# Response to Stolthaven development submission by OneSteel

OneSteel Wire Pty Ltd (OneSteel) operates the Newcastle Wire Mill (NWM) at Mayfield, NSW. Other OneSteel entities also occupy the same Mayfield site. The NWM is located immediately West of the existing Stolthaven Terminal and the location of the proposed expansion of this terminal. The railway line that provides the steel inputs into the NWM runs through the area of the proposed terminal expansion, and is also immediately adjacent to the boundary between the Stolthaven property and the NWM. The roadway on which Stolthaven distributes fuels from the terminal runs between OneSteel buildings. There are several office buildings immediately adjacent to this roadway. The OneSteel site typically has approximately 700 employees and contractors present during weekday working hours.

OneSteel objects to the proposed Stolthaven development because the health and safety of employees and contractors at the OneSteel site could potentially be compromised by the development. The work done by Stolthaven to assess the impact of the proposal on the health and safety of OneSteel employees and contractors is flawed and incomplete. The proposa

*Figure 1 Single Tank-top fire, ND16 – heat radiation of 4.7 kW/m<sup>2</sup> at 1.5m height*

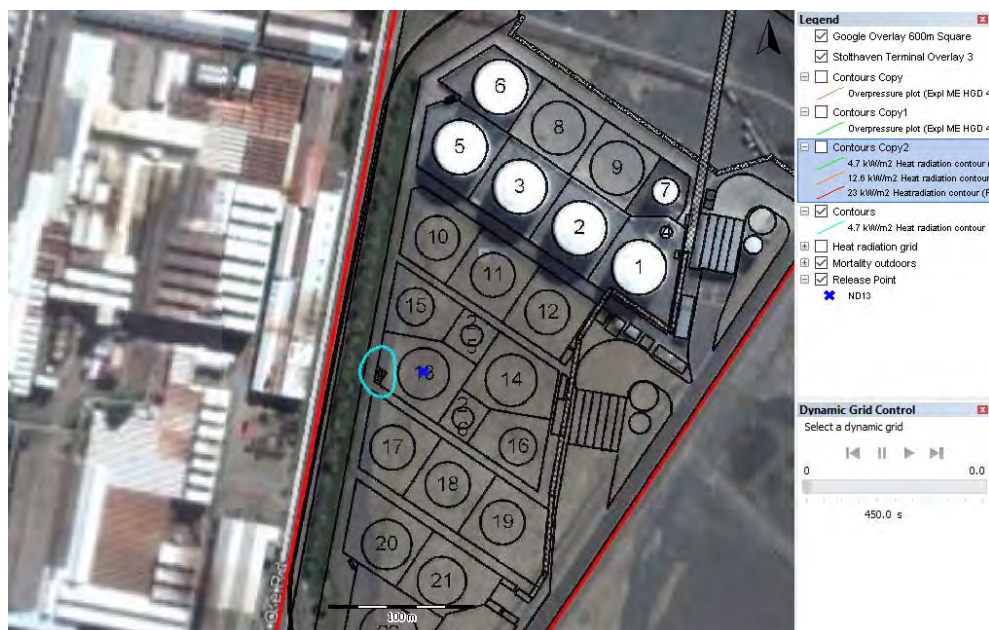
OneSteel's manufacturing operations are located within 100 metres of the proposed petrol storage tanks. At this distance it seems likely that our buildings would be subject to significant heat flux radiation or explosion overpressure in the event of an incident within the proposed development. The PHA does not provide details of consequence contours to allow OneSteel to understand sufficiently the potential impact of an incident on its buildings and infrastructure.

**Figure 7 FN Curve for Stolthaven Newcastle Terminal Stage 3**

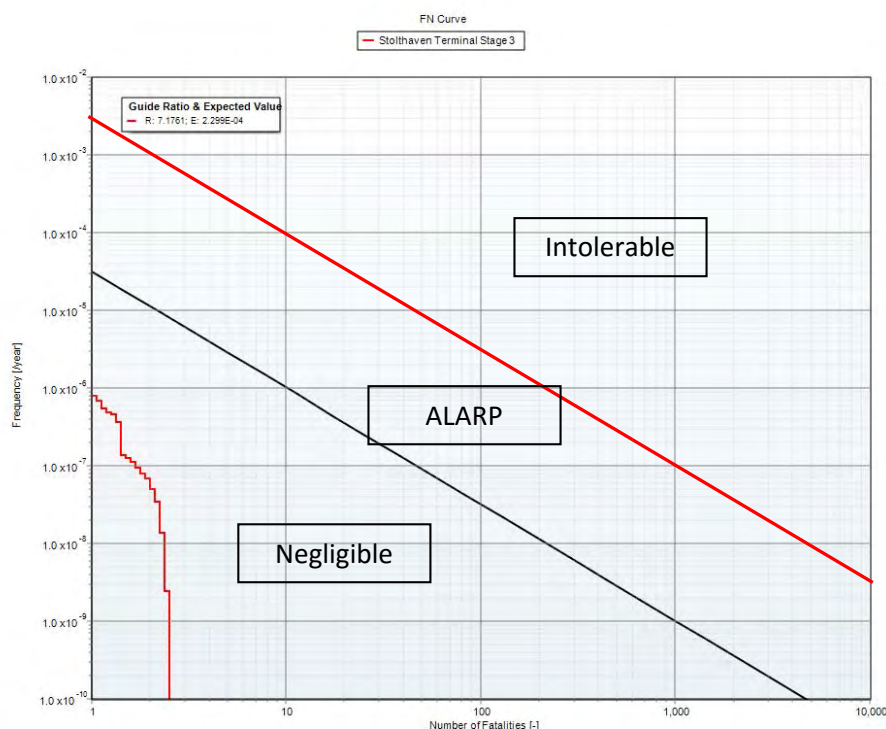
The PHA did not show building population data in making conclusions about risk to OneSteel employees and contractors. OneSteel is concerned that without the population data and the consequence contours used in the modelling being disclosed we are unable to determine if the resultant risk profile is representative of the current level of occupation, or a reasonably expected future level of occupation, of the industrial buildings located along the Western alignment of Iron Ore Road. As such, the submitted modelling may not be representative of the level of risk posed to OneSteel's employees.

Figure 9 Individual Injury Contours (Toxic Inhalation, Mild Transient Effects)

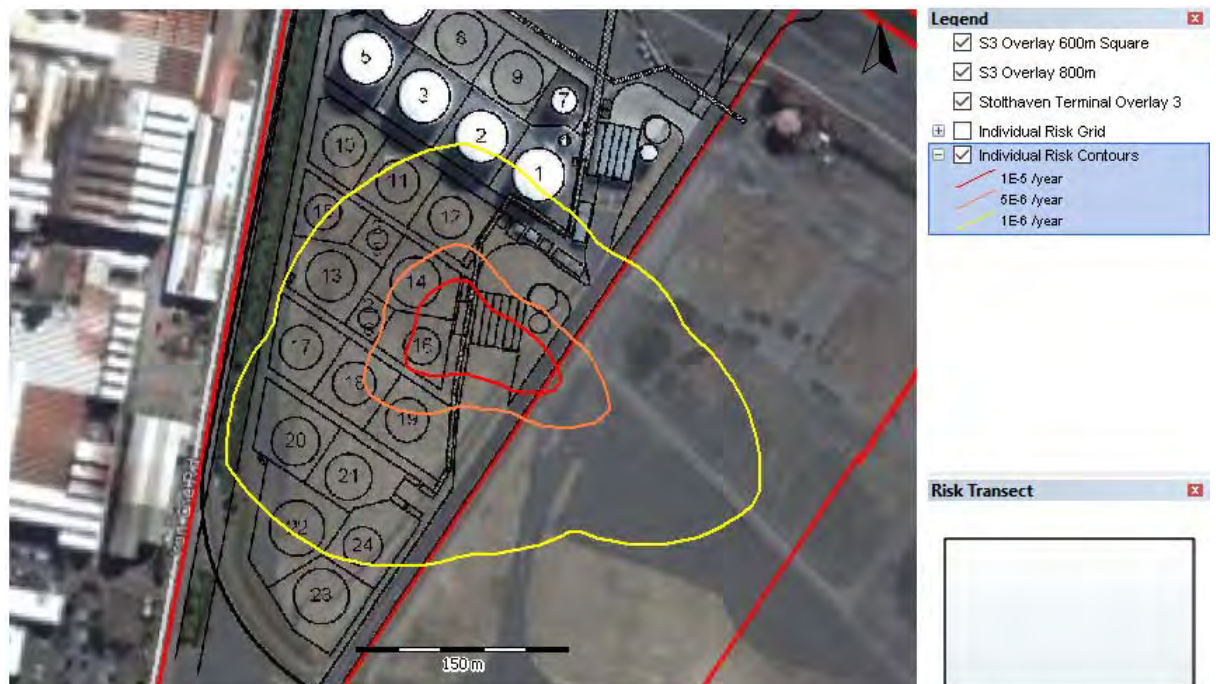
The PHA for the terminal operation notes that HIPAP 4 injury risk for toxic exposure was not applicable as the PHA did not involve any release scenarios of toxic materials resulting in acute, chronic or delayed effects. This decision (not to examine potential injury risk due to toxic exposure) is contrary to the Air Quality Impact Assessment document which shows carcinogens such as benzene are contained in some streams. It is also contrary to statements by the EPA when they fined Stolthaven in 2015 for "...exceeding the limits provided by the licence for VOC's and benzene." (EPA media release 27 May 2015).

**Figure 11 23 kW/m<sup>2</sup> (blue), flash fire and 14 kPa Contours (southerly wind)**

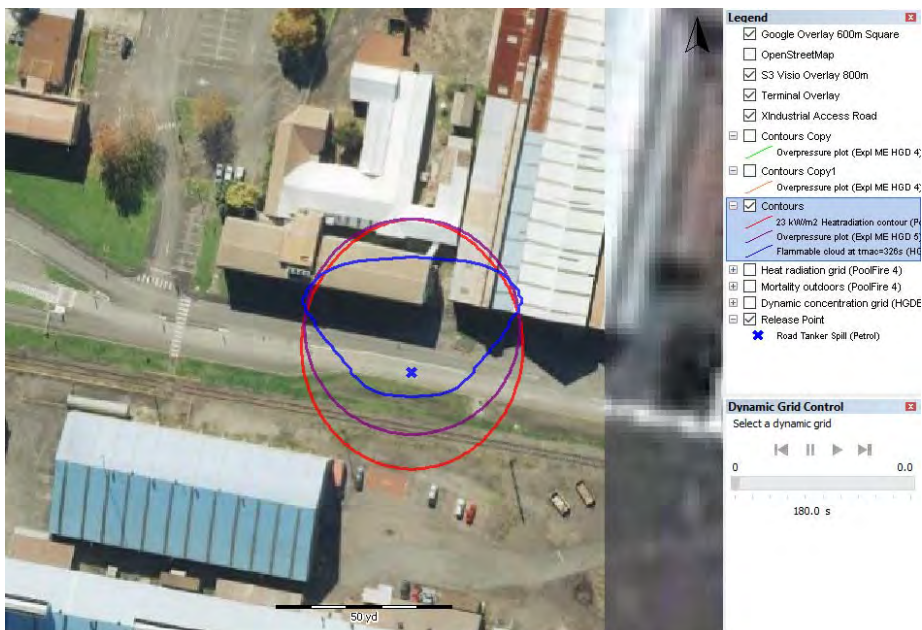
- It has not provided details of the consequence contours and population data from which the risk contours were developed to allow transparency of the risk contour modelling, and
- No modelling of transport incidents has been included along Steelworks Road adjacent to the existing office buildings that have significant populations occupying them

It is expected that the risk contours in this location will demonstrate significant risk to the occupants of these office buildings. This level of risk is not reflected in the risk contours developed for locations along Industrial Highway and Ingall Street as there are no significant populations close to the road in these locations.
